Subject: Response To Application Number EP/124/19/PL at Rear of 16 Worthing Road East Preston BN16 1AZ

WEST SUSSEX COUNTY COUNCIL CONSULTATION

TO:	Arun District Council FAO: Anita Gardner
FROM:	WSCC - Highways Authority
DATE:	11 October 2019
LOCATION:	Rear of 16 Worthing Road East Preston BN16 1AZ
SUBJECT:	EP/124/19/PL 1 No. new detached single storey dwelling with associated access driveway & external works.
DATE OF SITE VISIT:	n/a
RECOMMENDATION:	Advice
S106 CONTRIBUTION TOTAL:	n/a

Image below: proposed block plan (n.t.s.)

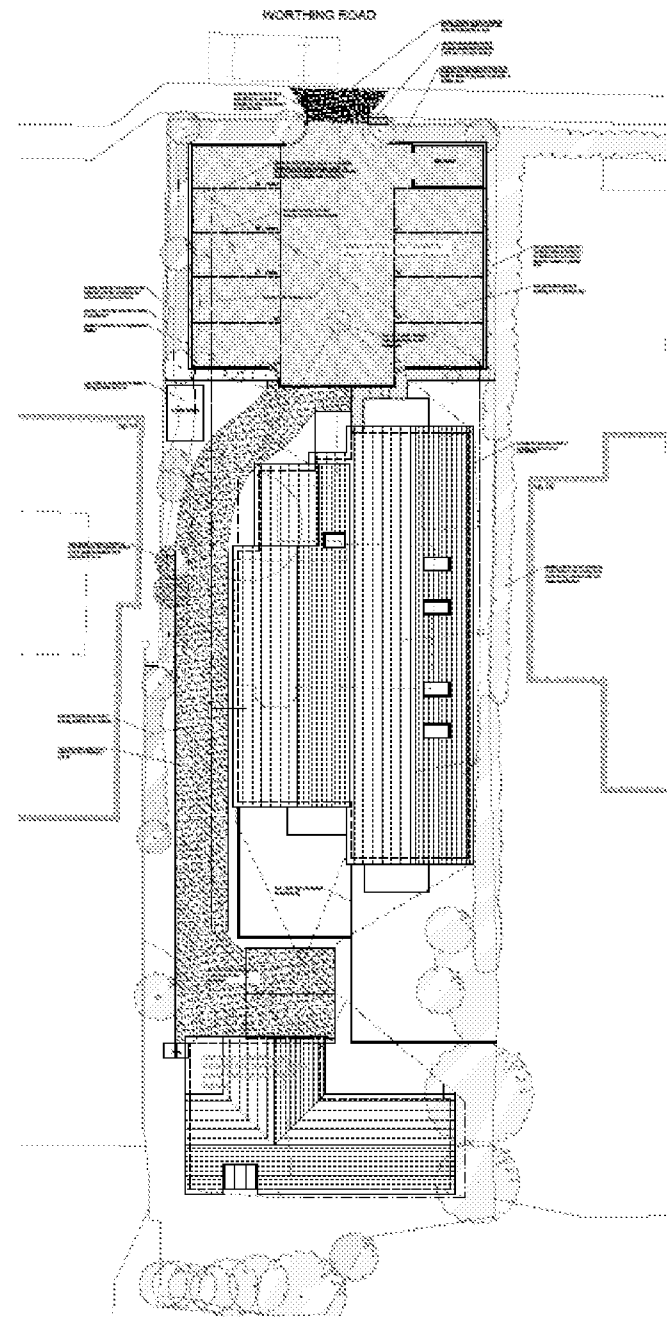
The plans indicate that a turning area will be provided within site. However, this is likely to require a multi-point manoeuvre to allow vehicles to egress in a forward gear. It is also possible that a vehicle parked in the southernmost bay may not be able to turn on site if a vehicle was parked in the adjacent bay. In order to improve manoeuvrability for vehicles, the applicant should consider increasing the turning space to the rear of the proposed bays to a minimum depth of 6m. There appears to be sufficient space on site for this to be accommodated. The LHA could not substantiate an objection on highways safety under the proposed arrangement as it is anticipated that vehicles could turn within the northern parking area for the flats and will enter onto the public highway in a forward gear.

No part of the development shall be first occupied until the vehicle parking and turning spaces have been constructed in accordance with the approved site plan. These spaces shall thereafter be retained for their designated use.
